Our ref: HE551507-MMSJV-LSI-000-CO-UU-0002

Infrastructure Planning (Examination Procedure) Rules 2010 – Request by the Examining Authority for further information under Rule 17

Application Ref TR010036 - A303 Sparkford to Ilchester dualling scheme

I refer to the Examining Authority's letter dated 11 March 2019, requesting further information in relation to our application to make a material change to our application for a Development Consent Order.

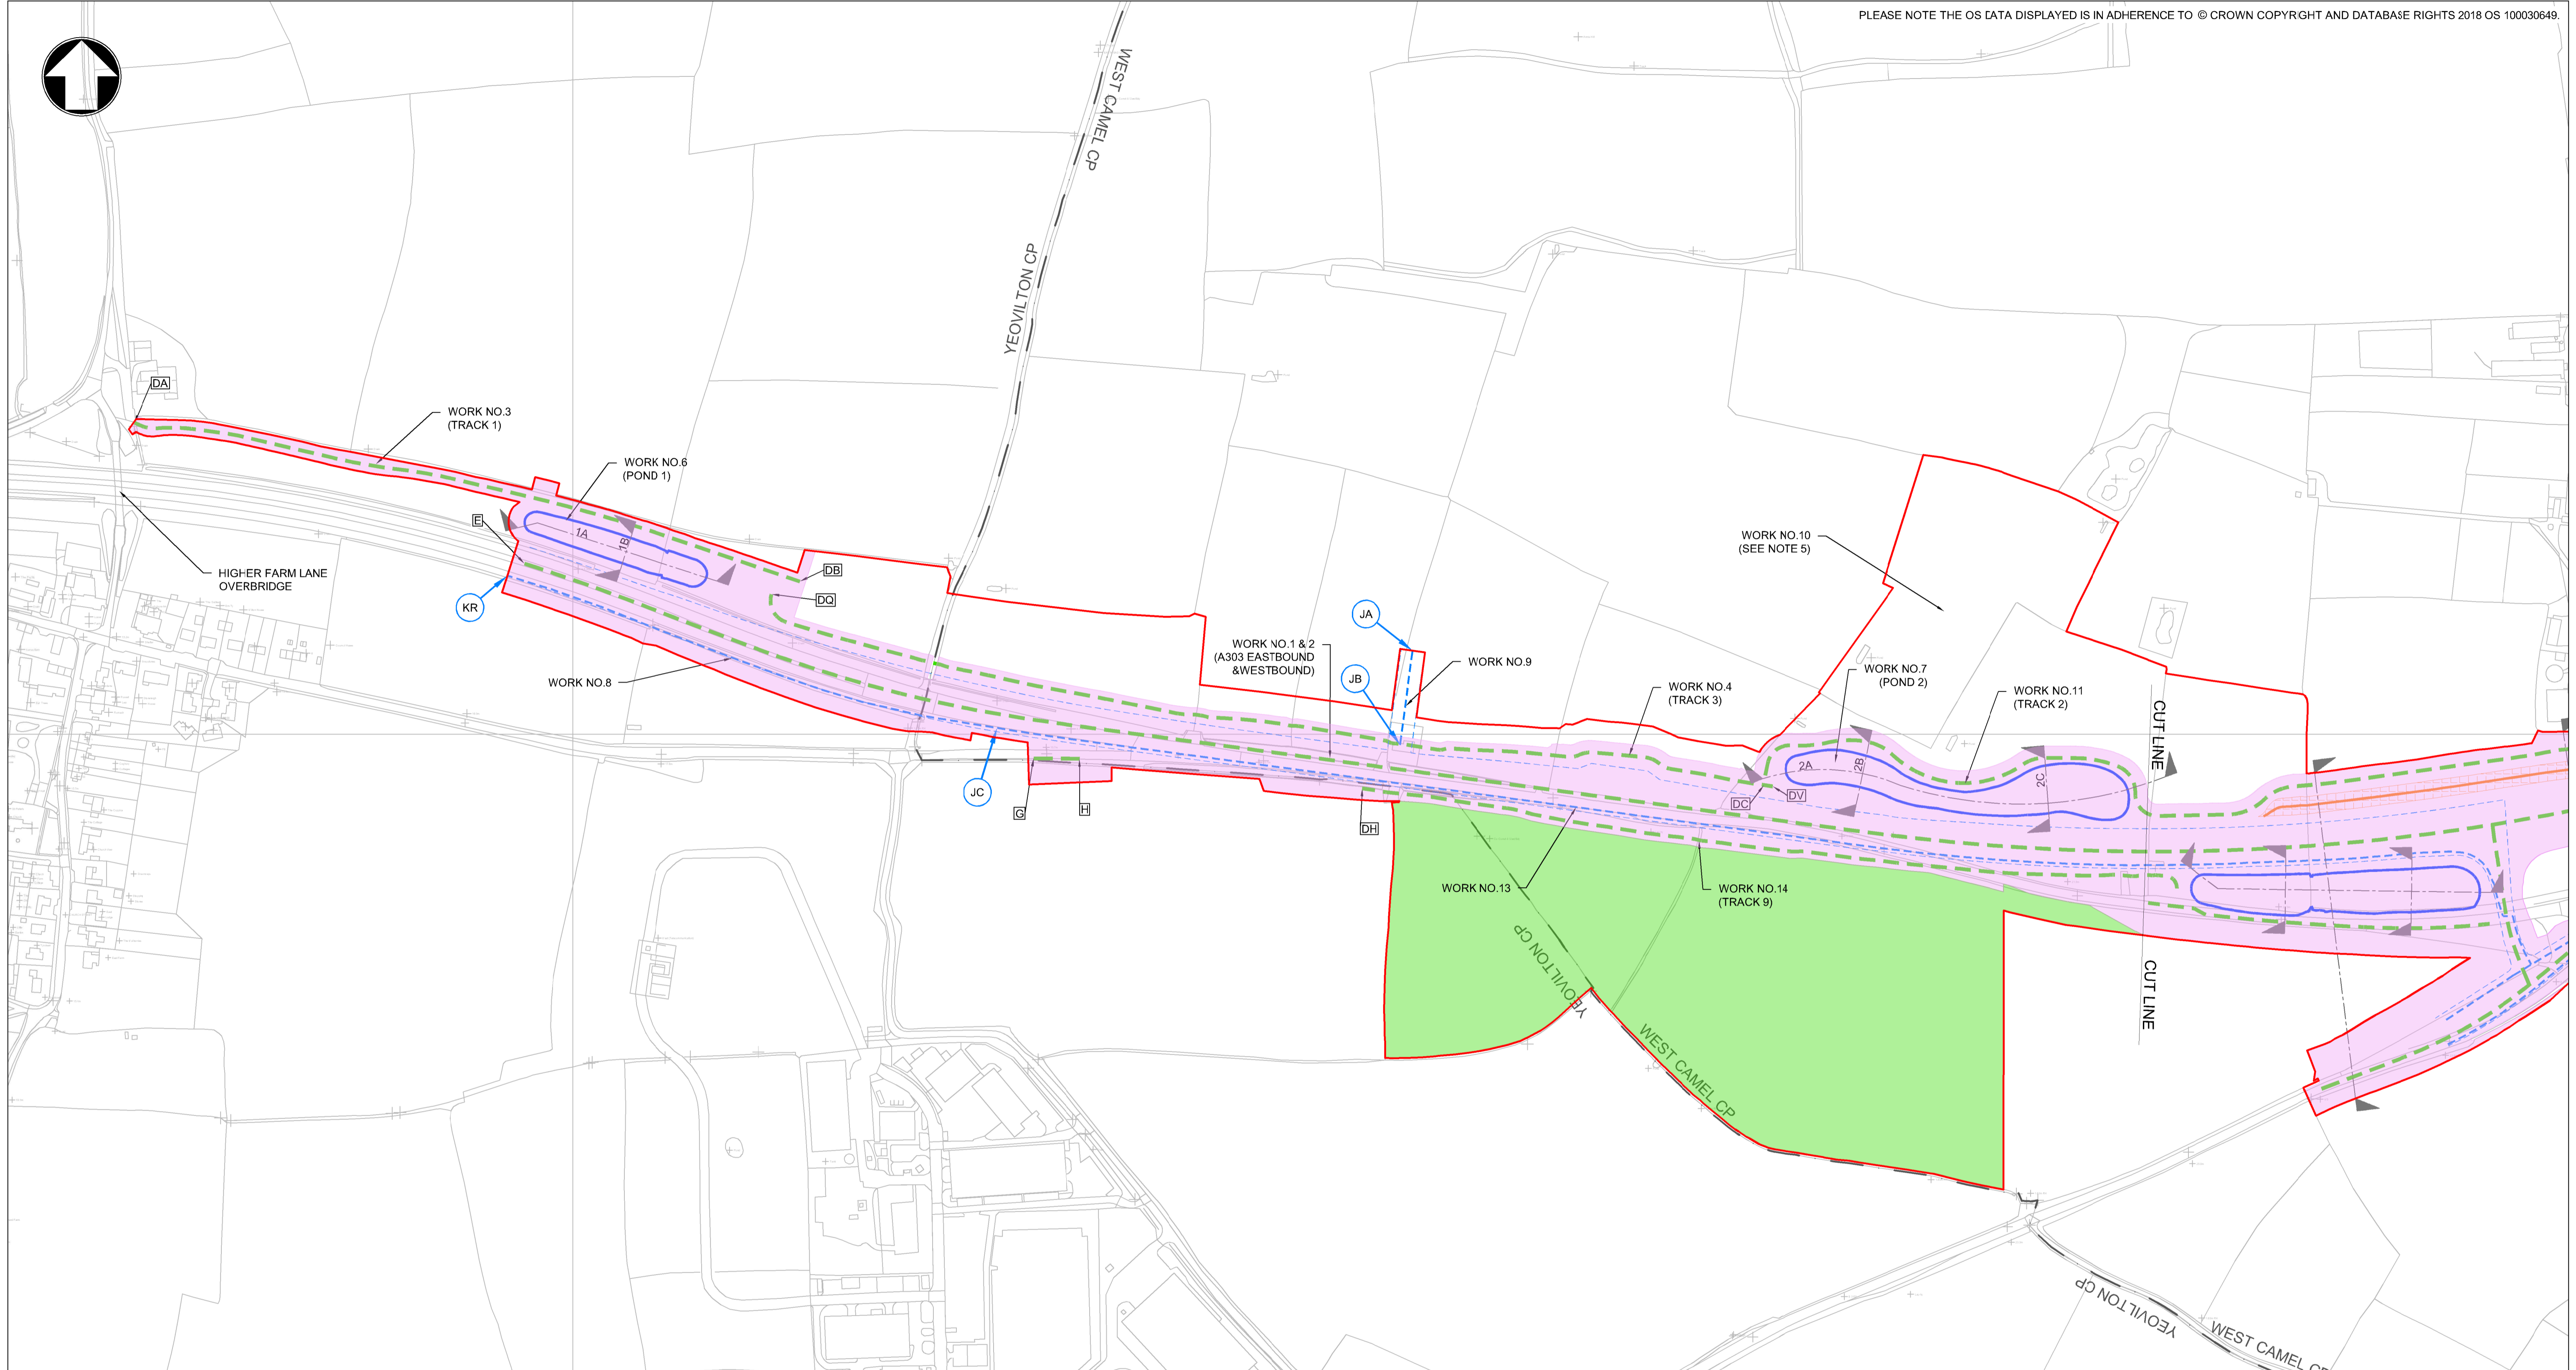
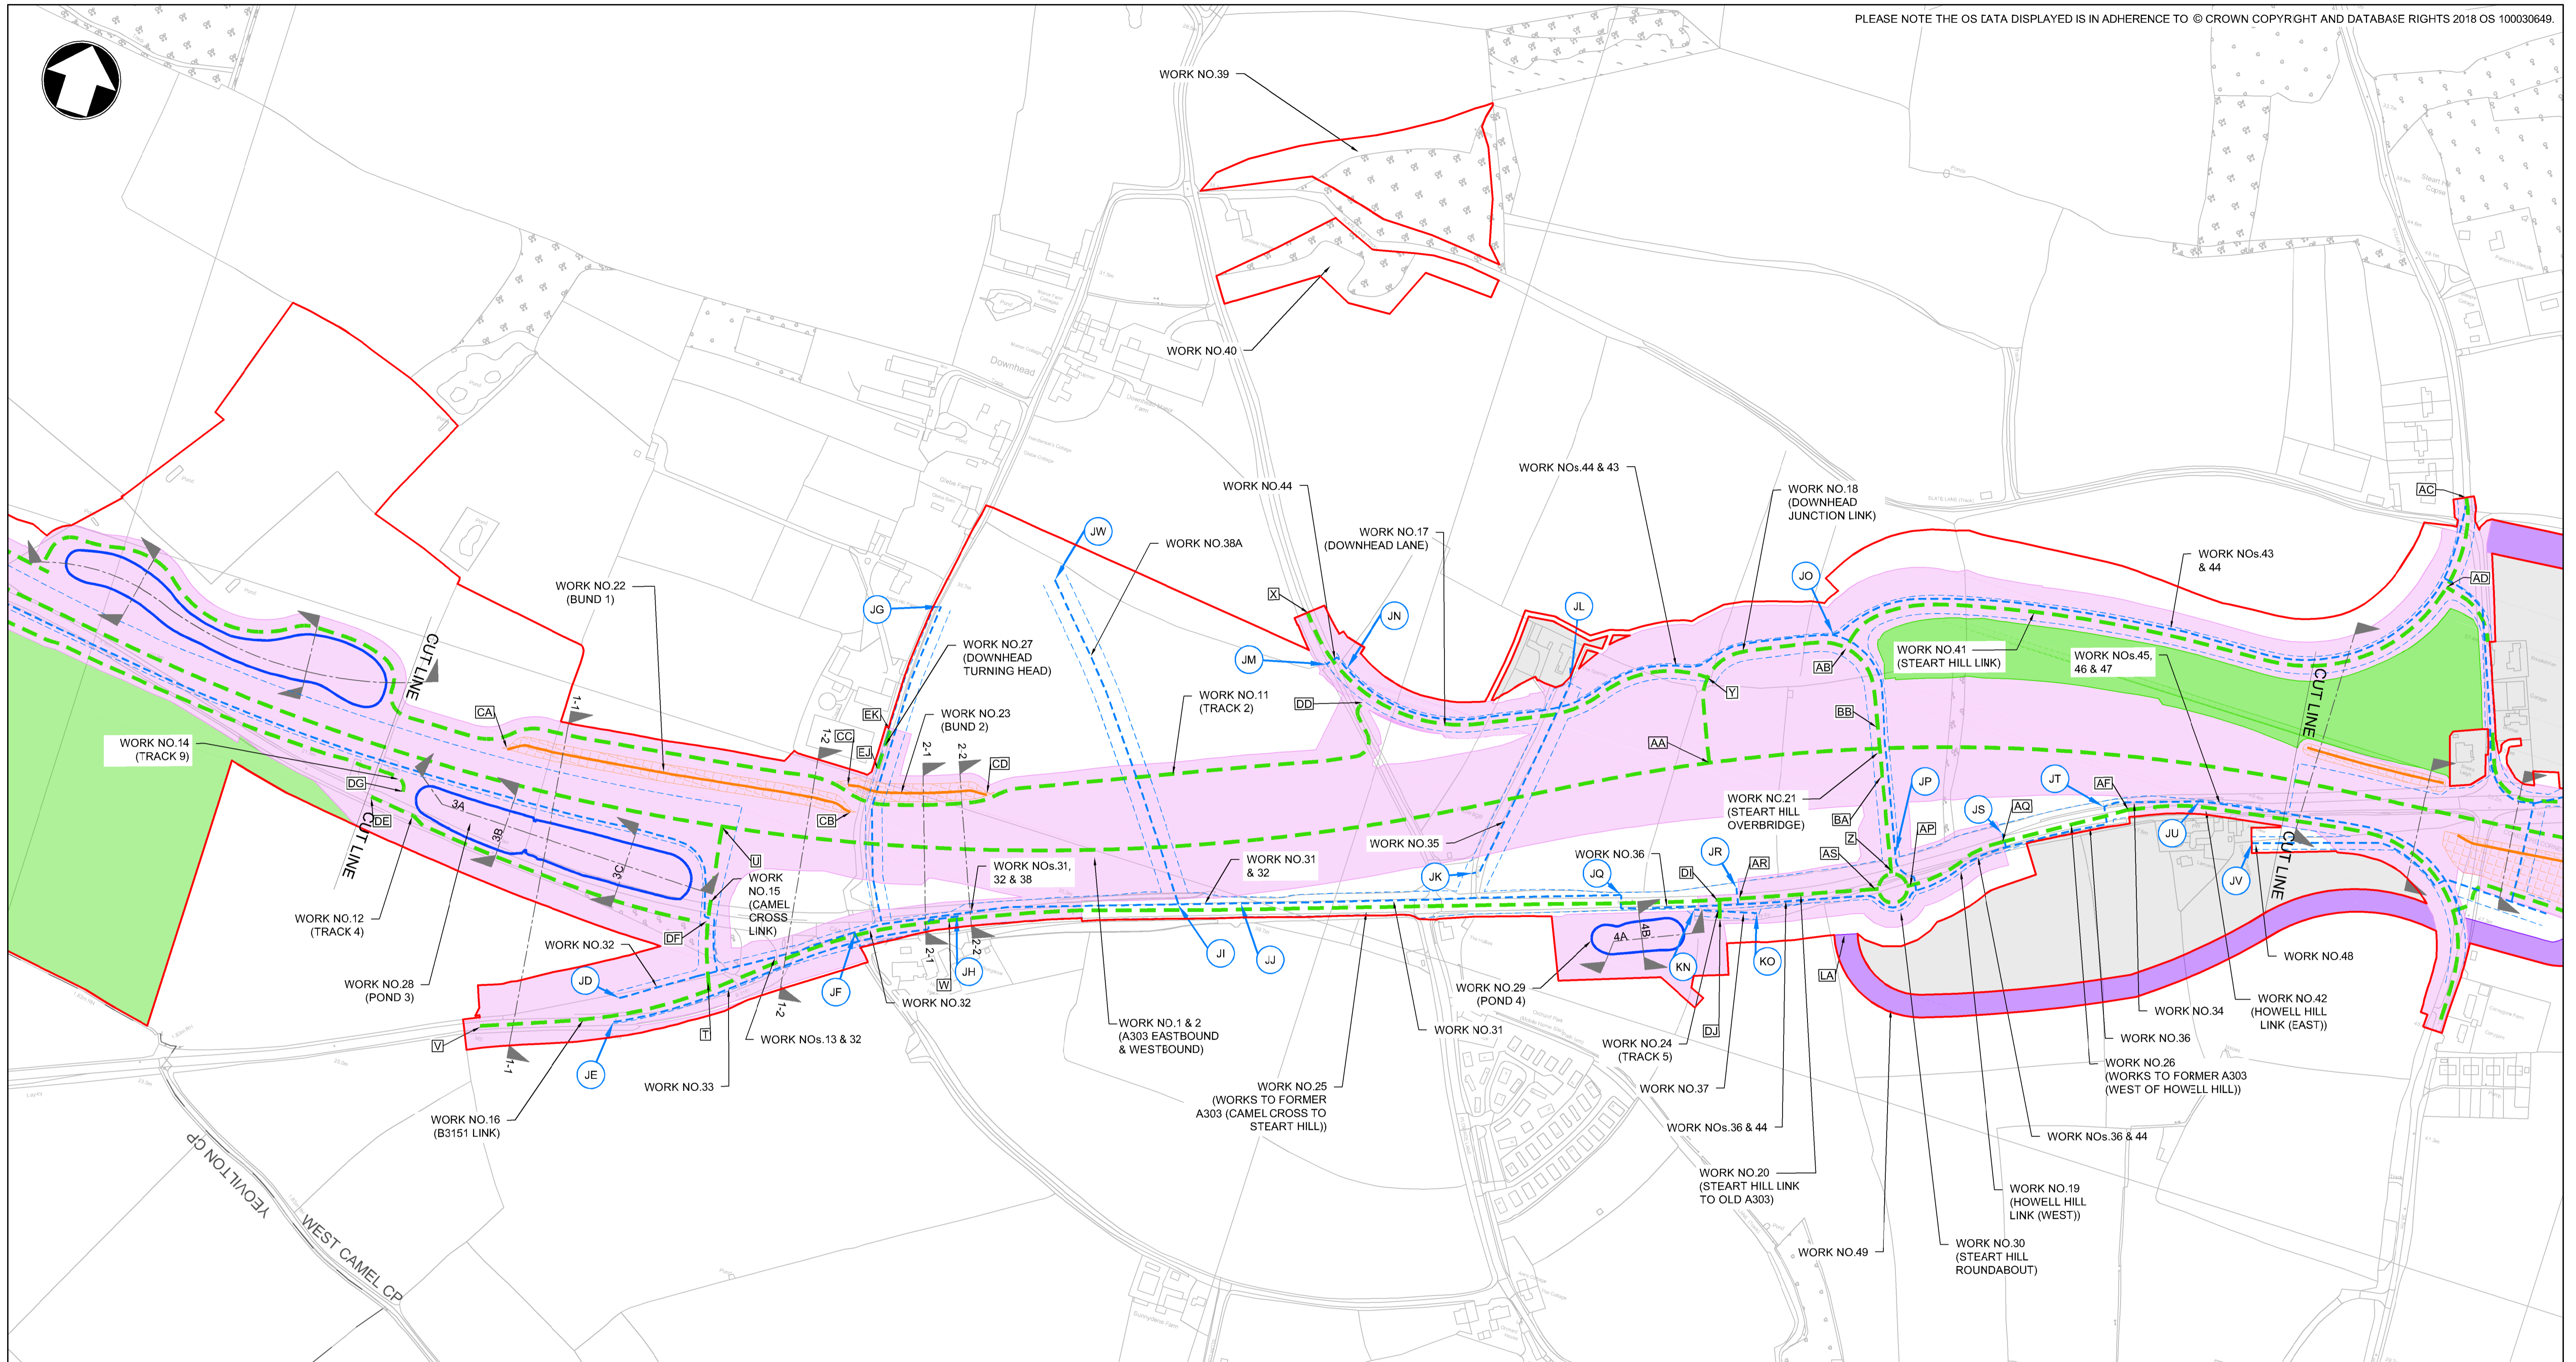
For the avoidance of doubt, the Applicant requests that as part of this material change request, Work Number 59 is removed from the Application, which was for the proposed construction of an accommodation track for Blackwell Farm between points DR and DS.

The Applicant requests that Work Number 104 is included within the Application, which is the proposed widening of the carriageway of the public highway at the junction between Traits Lane and Blackwell Road.
